WELWYN HATFIELD COUNCIL – DEVELOPMENT CONTROL
DELEGATED REPORT

APPLICATION No:	S6/2010/1555/FP
------------------------	------------------------

DESCRIPTION OF PROPOSAL:

PROPOSED REAR ELEVATION

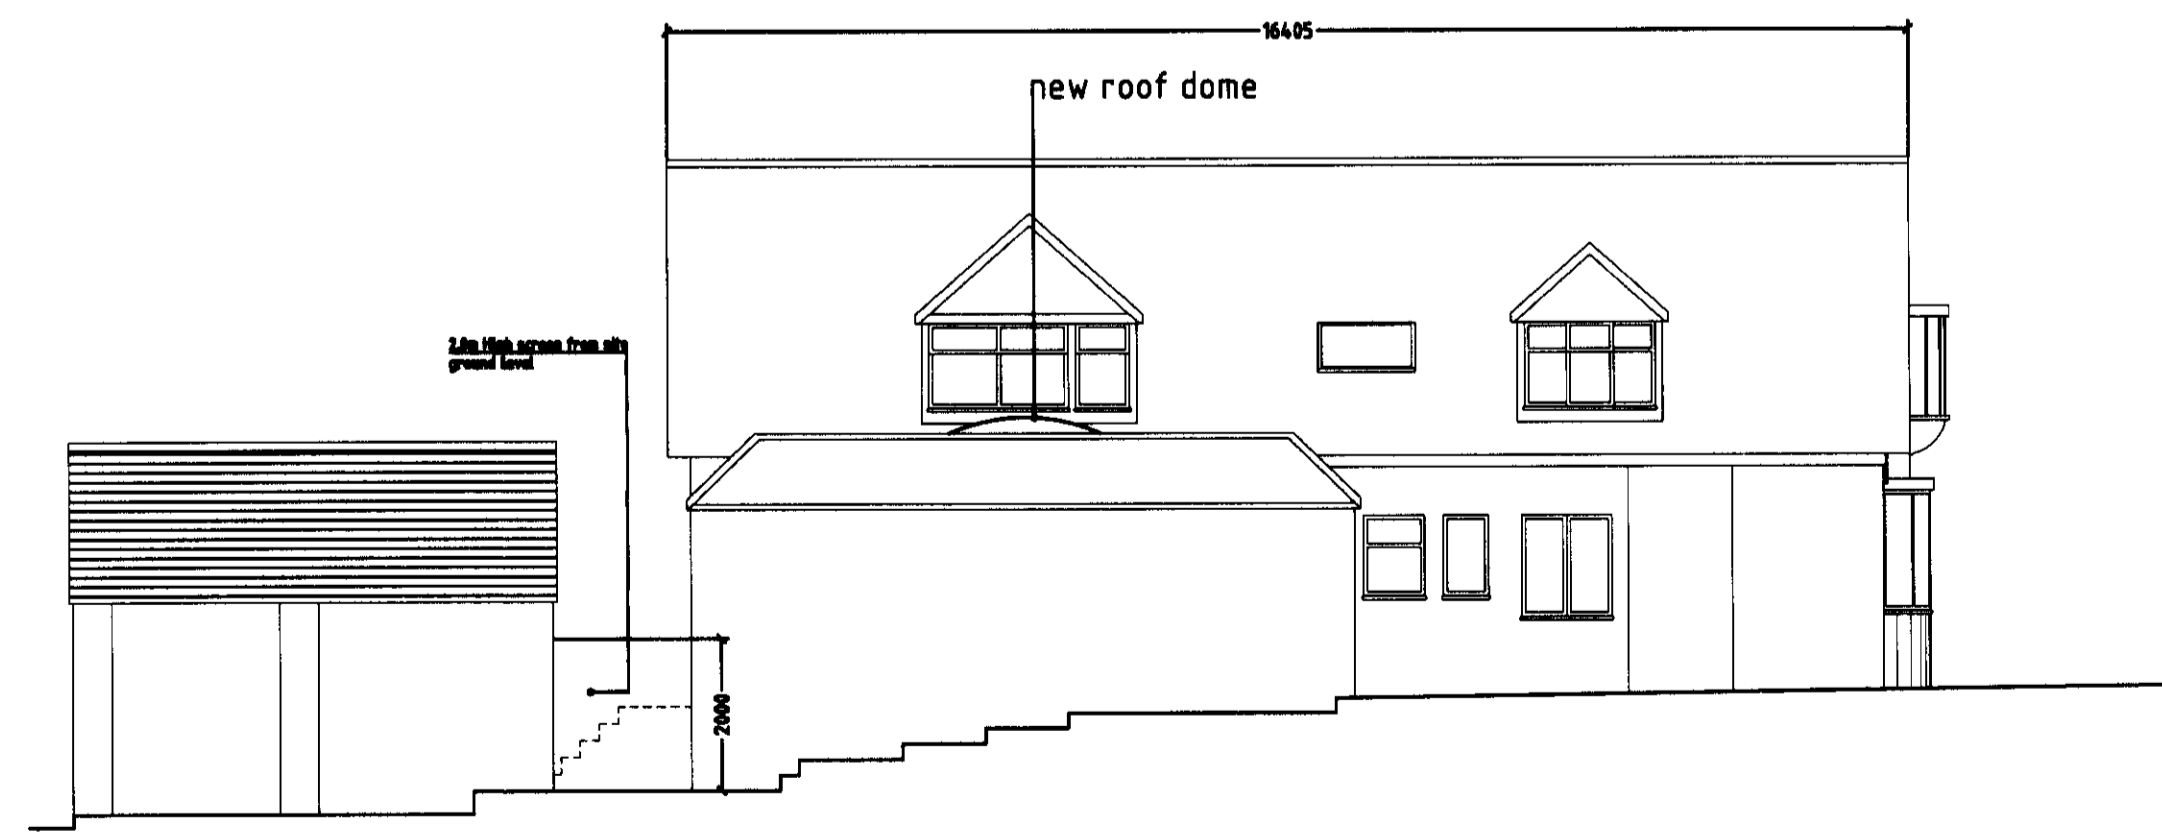
The changes in this application relate to the increase on depth of 0.6m to the depth of the garage extension and a roof dome.

The height of the garage extension was already approved in the 2007 application and so the issue relates to the proposed increase in depth of approximately 0.6m of the garage.

The letter from No.83 The Ridgeway states that this garage extension would be approximately 2.2m beyond their rear elevation. The depth of projection, even being increased by 0.6m, is not considered to have a significant impact on the residential amenity of No.83. Although this extension will have a visual impact on the residential amenity of No.83 The Ridgeway, the issue here is whether this impact would be harmful.

Taking into account the height of the proposed garage, and its projecting depth, it is not considered that this extension will be unduly prominent from either the existing rear terrace of No.83 The Ridgeway or when viewed through the windows of this neighbour.

Concerns have been raised by No.83 The Ridgeway in regards to overlooking. The proposed rear garage window would not result in any significant loss of privacy to this neighbour. The proposed rear platform and steps to the garden have been amended in the latest design drawings so that they are no longer close to the common boundary with this neighbour. The boundary treatment between the garage and existing shed is also shown on the drawings as being 2m high. These details will ensure that there is no significant loss of privacy from the new platform and steps for No.83 The Ridgeway.

The latest set of drawings have also changed the rear first floor balcony to a window and this again will prevent any significant overlooking to neighbours.

3. The 2m high boundary treatment with No.83 The Ridgeway shall be completed in accordance with the details shown on approved drawing rid/10/plan 1b and shall remain in that form thereafter.

PROPOSED GROUND FLOOR LAYOUT

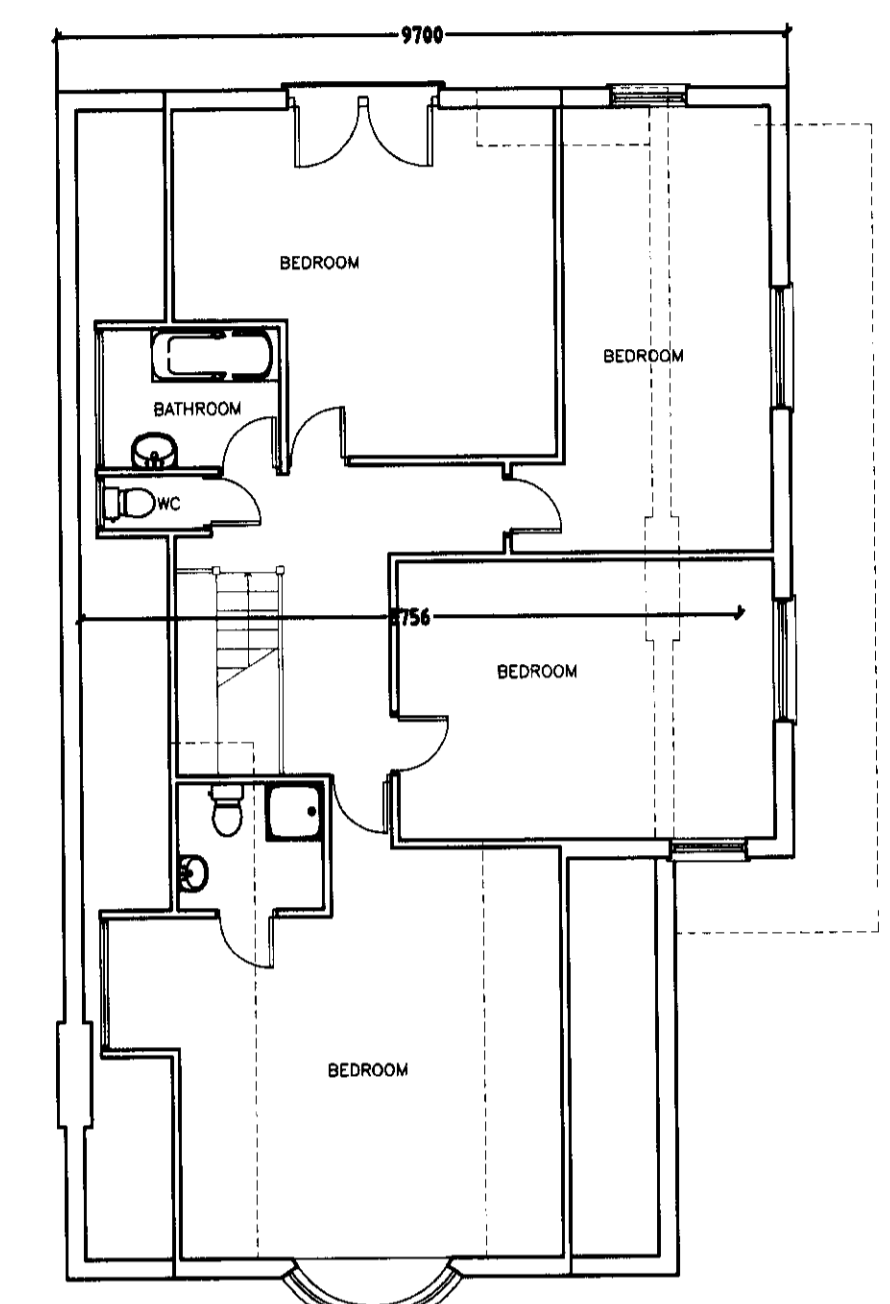
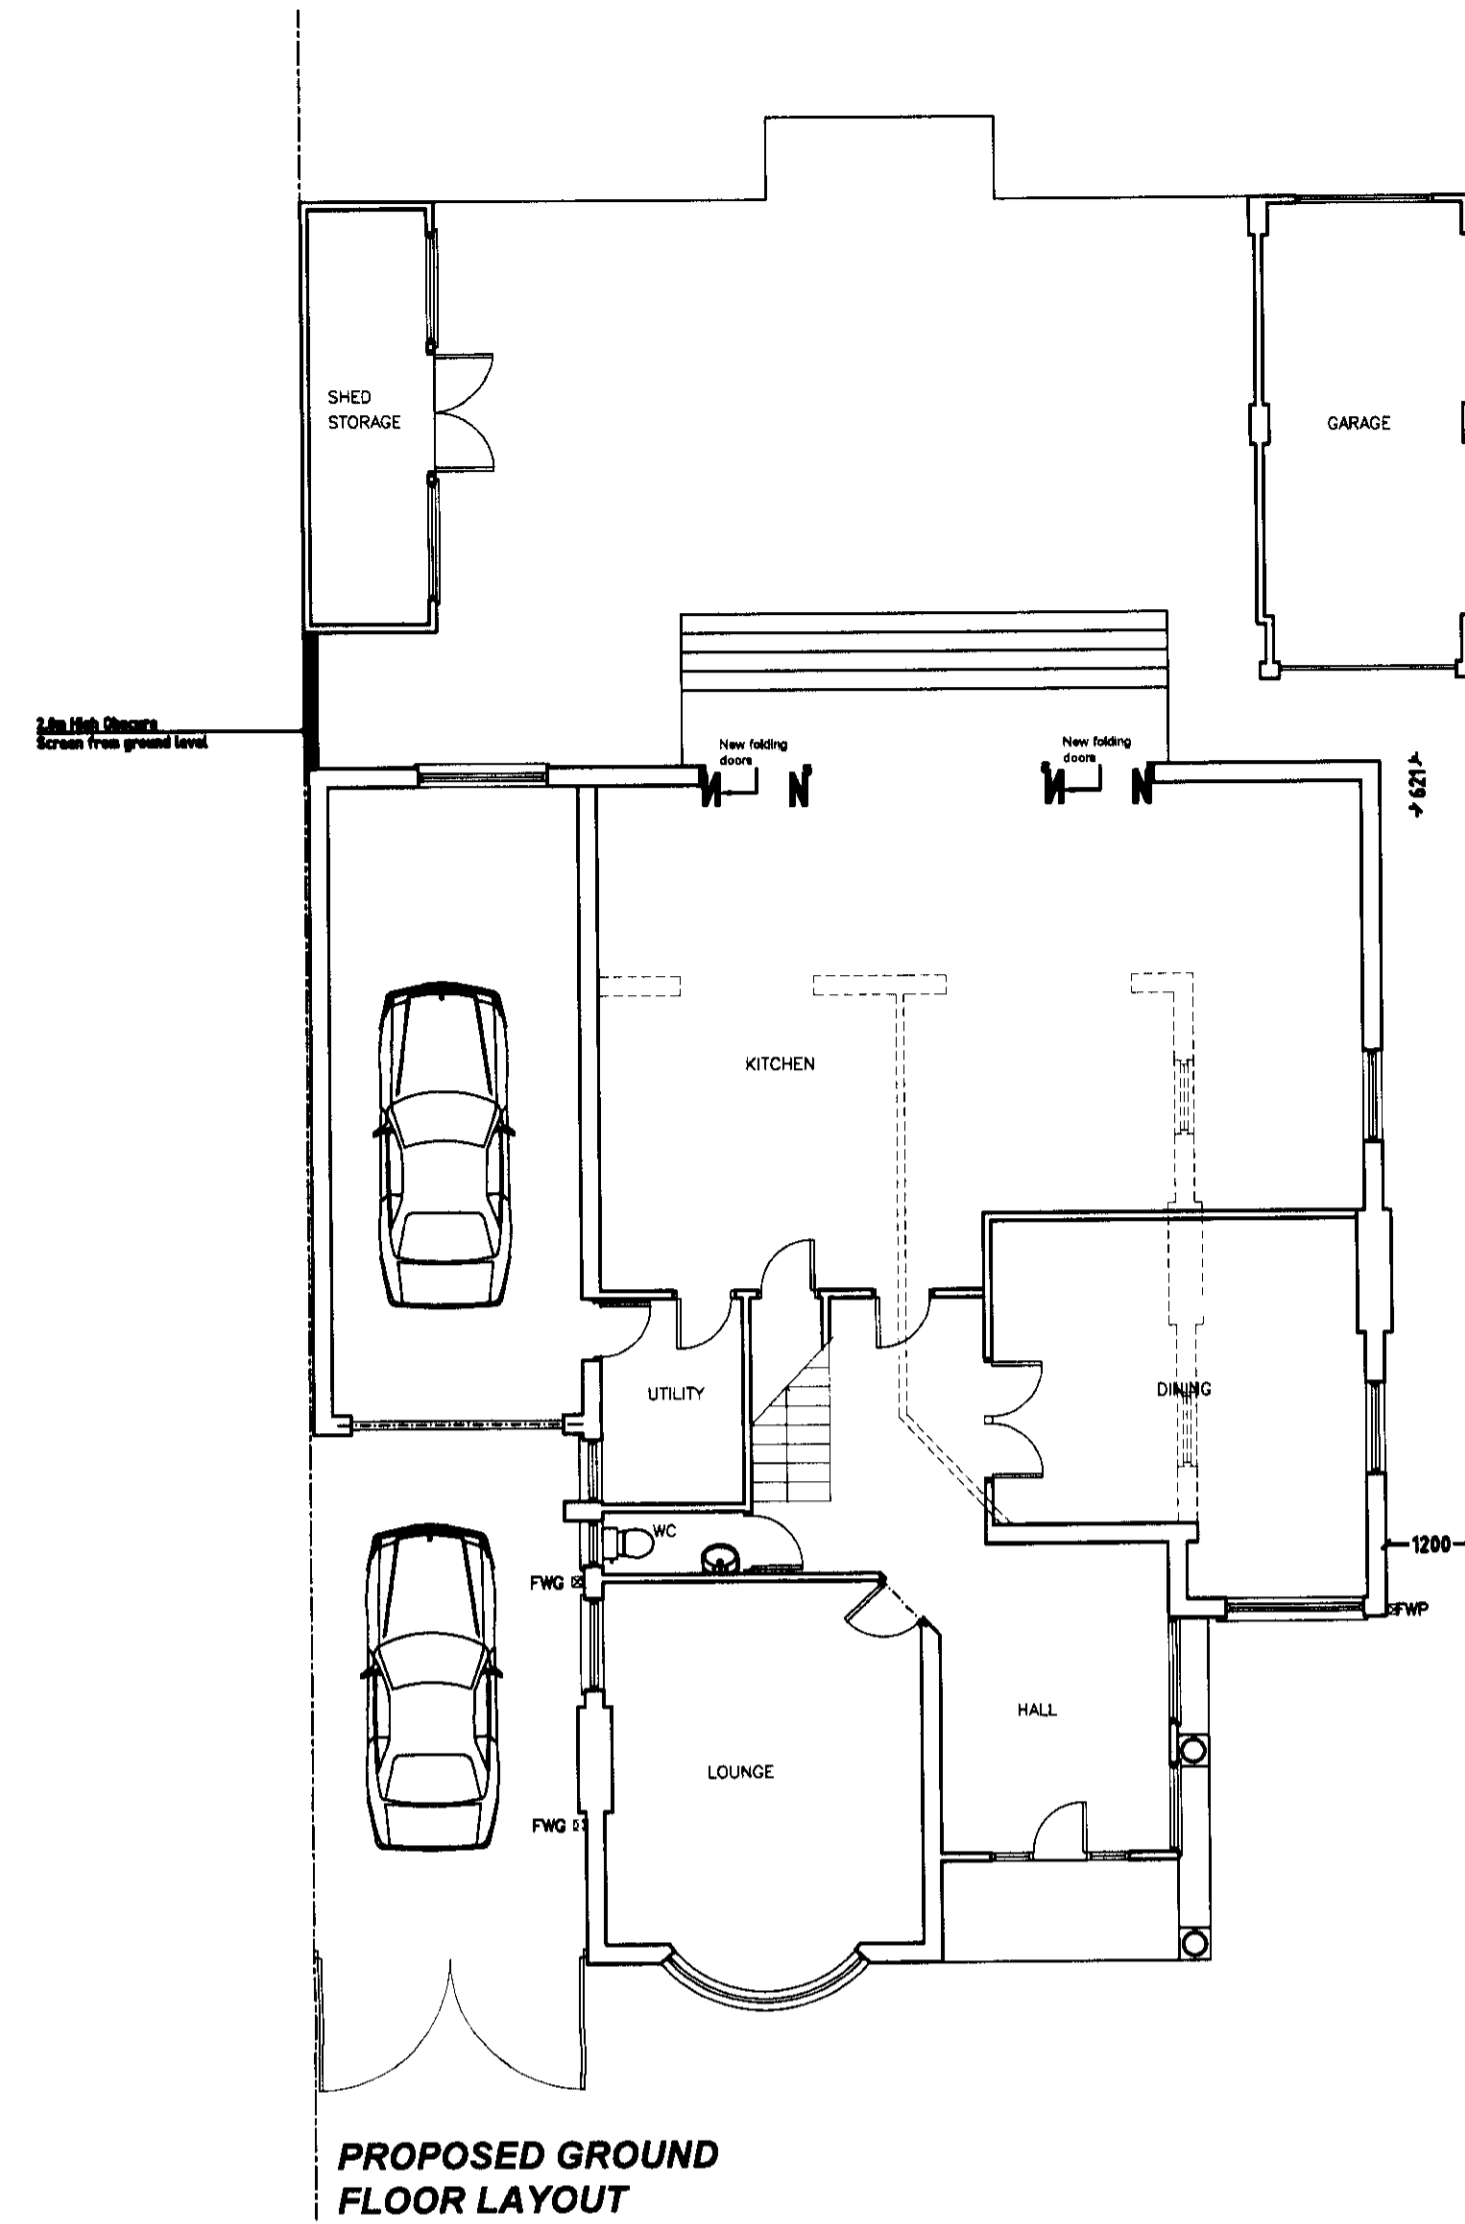
The proposed ground floor side windows which are near the boundary with No.87 The Ridgeway are larger and lower than that previously approved and so a planning condition should require them to be obscure glazed as they will look out onto the adjoining neighbour.

6. C.7.9 – On the west side elevation of the proposed building the windows at ground floor level for the dining room and kitchen along with those for the bedrooms (on approved drawing rid/10/plan received and dated 23 August 2010) shall be glazed with obscured glass and shall be fixed so as to be incapable of being opened below a height of 1.8 metres above floor level, and shall be retained in that form thereafter.
